WEST SUSSEX COUNTY COUNCIL CONSULTATION

TO:	Arun District Council FAO: Maria Tomalova
FROM:	WSCC - Highways Authority
DATE:	4 June 2019
LOCATION:	Flat 1a, 1 Queens Square, Bognor Regis, PO21 1SA
SUBJECT:	BR/160/19/PL Change of use from house in multiple occupation (C4 House in Multiple Occupation) to 4 No. self contained flats (C3 Dwelling houses).
DATE OF SITE VISIT:	N/A
RECOMMENDATION:	Advice
S106 CONTRIBUTION TOTAL:	£N/A

Title
Plans+ Elevations as Proposed

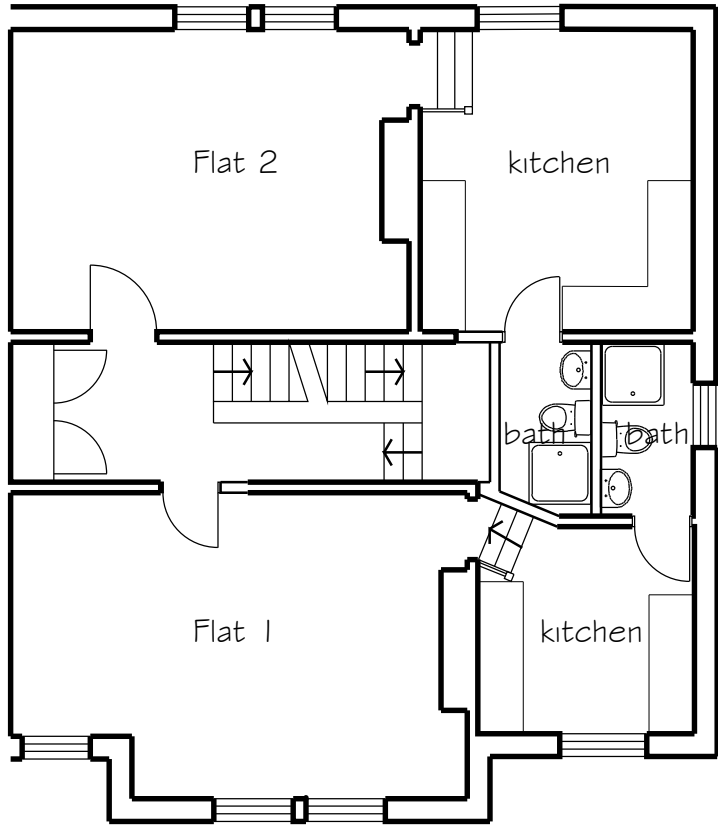
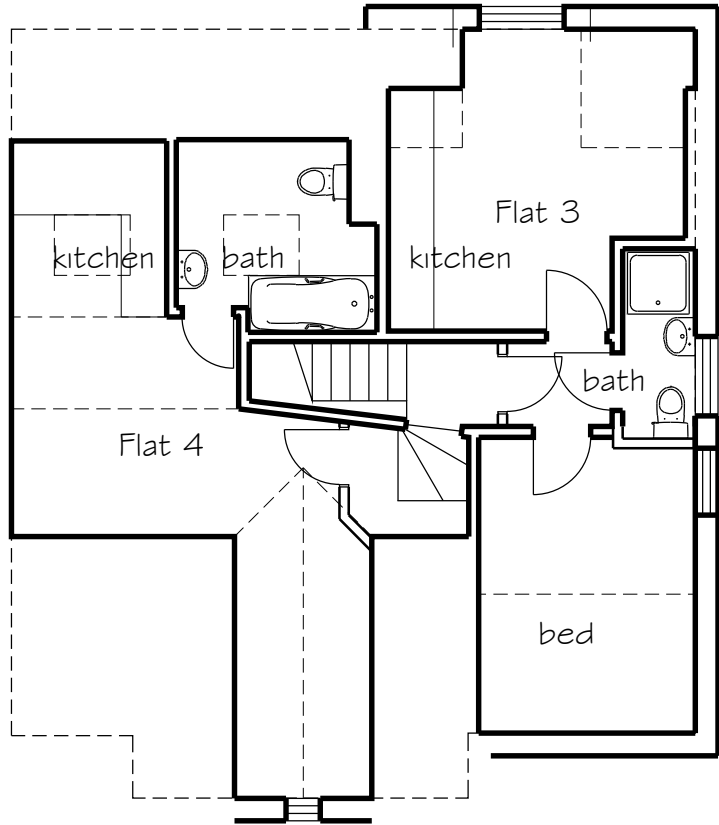
Secure and covered cycle storage was not demonstrated in the plans. The inclusion of cycle storage increases the sustainability of the site by offering alternative modes of transport to the private car.

No part of the development shall be first occupied until covered and secure cycle parking spaces have been provided in accordance with plans and details to be submitted to and approved by the Local Planning Authority.
